Your Ref: OWPC15170
Our Ref: A/121/17/HH 21-06-2017
Please ask for:
Mrs A Gardner

Detached double garage & single storey extensions to existing garage.
Harcourt West Drive Angmering

<table><tr><td>PROJECT HARDCOURT West Drive, Angmering Littlehampton. BN16 4JE</td><td rowspan="4"> 29 Breach Avenue, Southbourne, Emsworth, Hampshire. PO10 8NB T: 01243 697164 M: 07879471666 www.pdkconsulting.co.uk</td><td rowspan="4"> PDK Architecture and Surveying</td></tr><tr><td colspan="2">DRAWING PROPOSED SITE PLAN</td></tr></table>

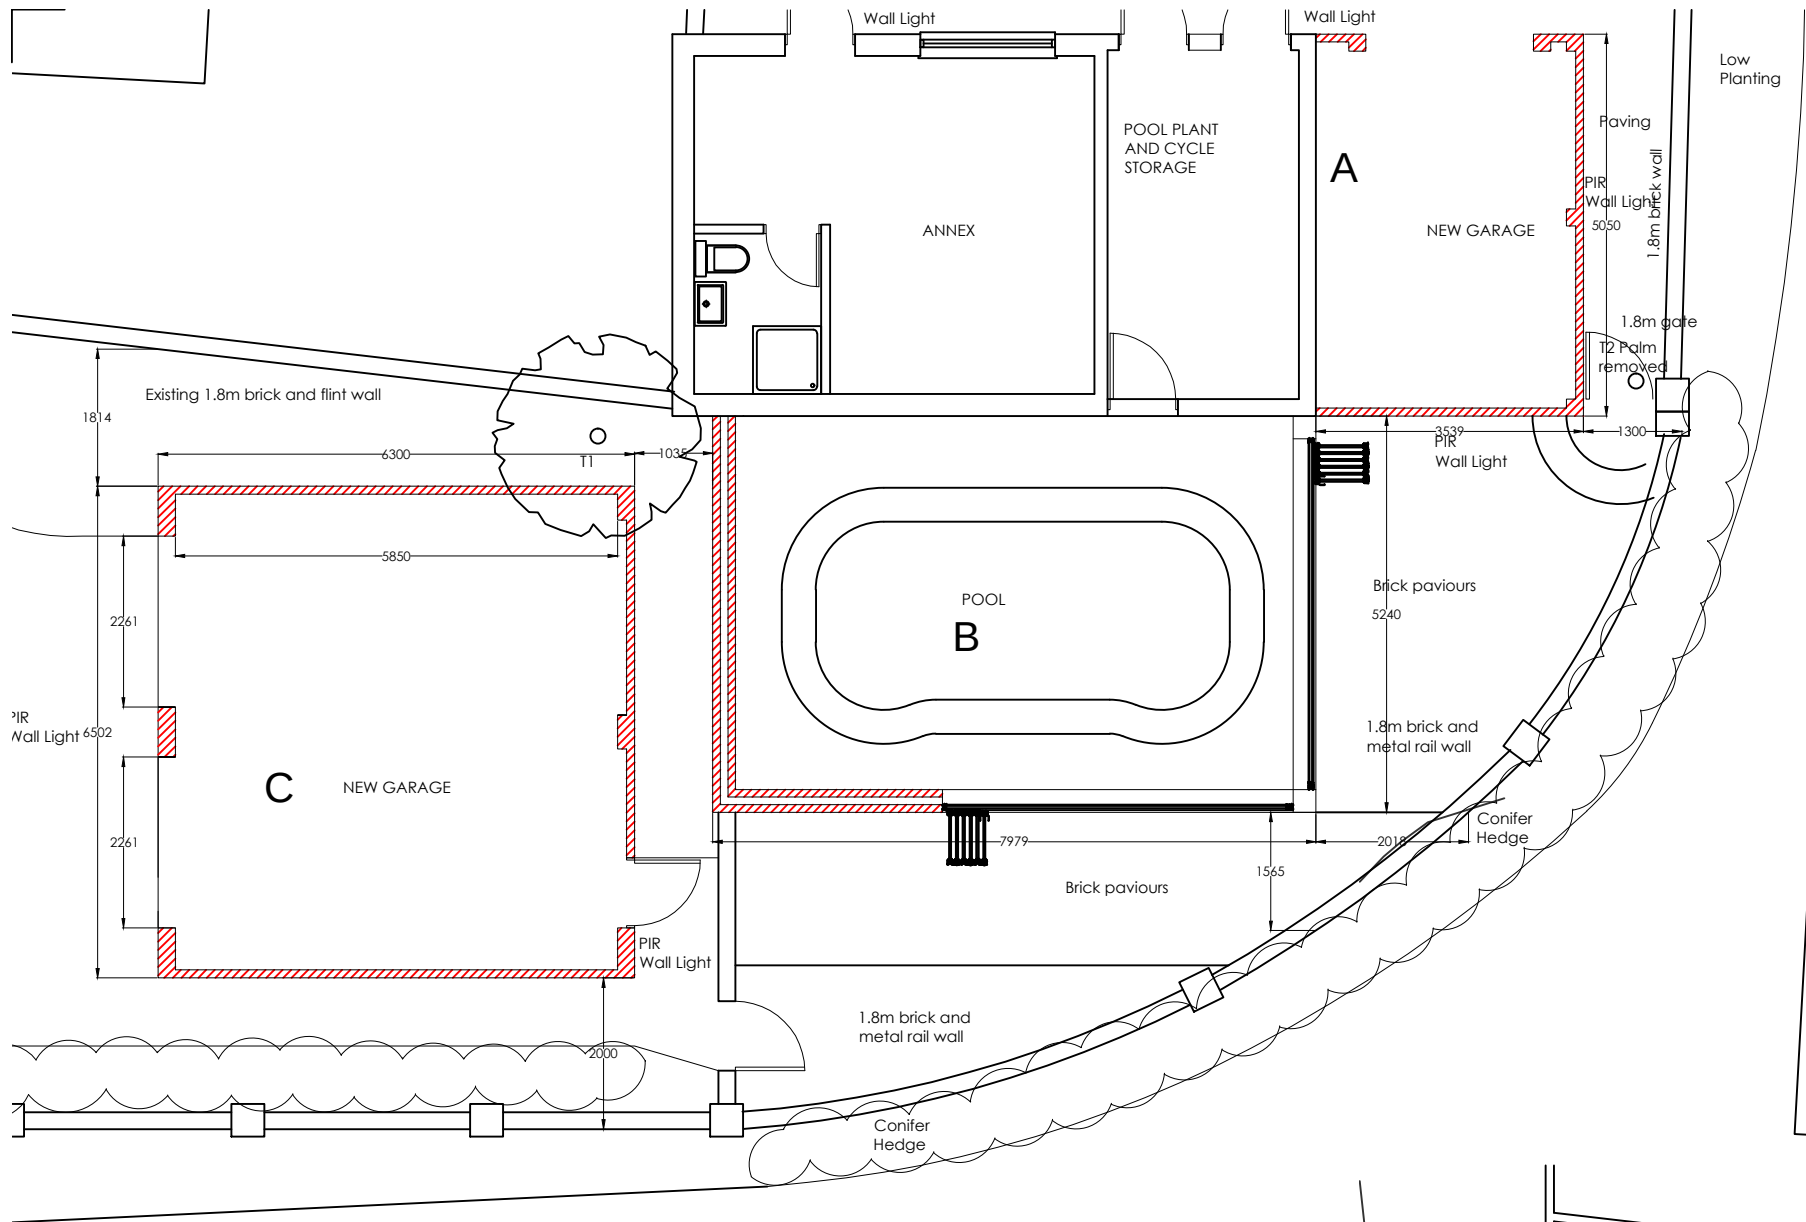
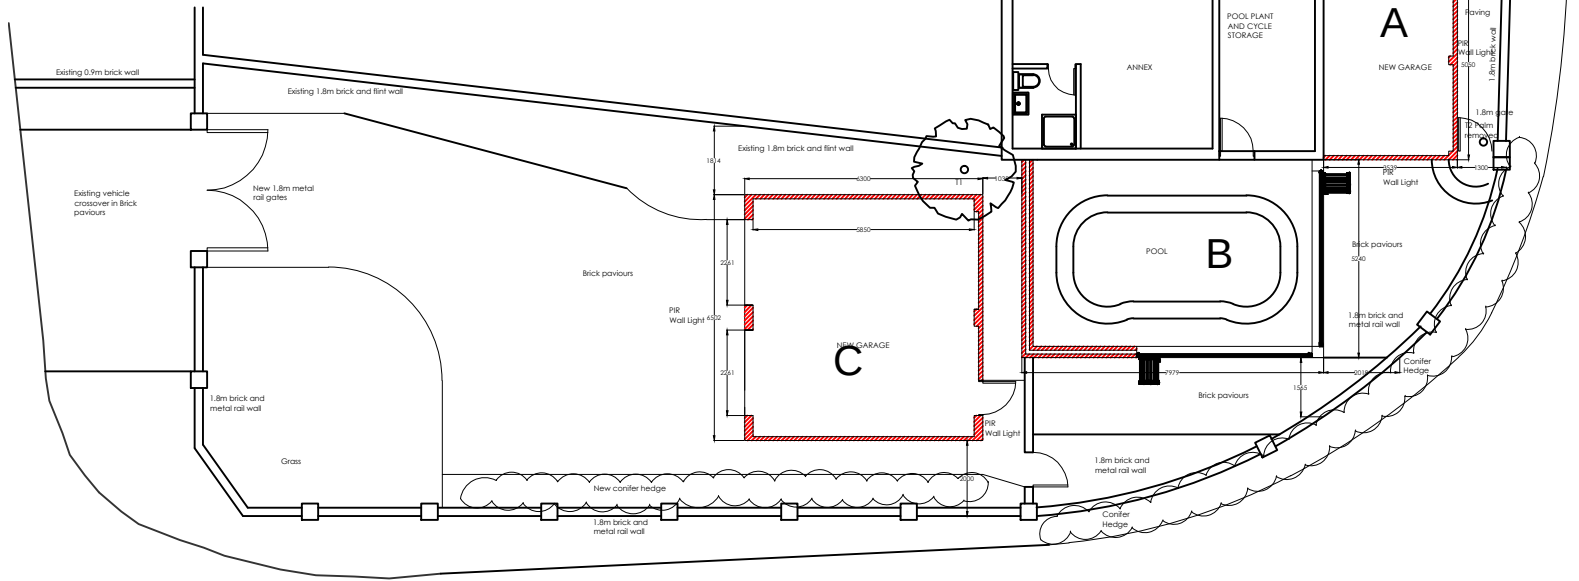
This building is too near the road which will make it a safety hazard and will cause visual impairment to the surrounding properties and to members and visitors to the Golf .Club.
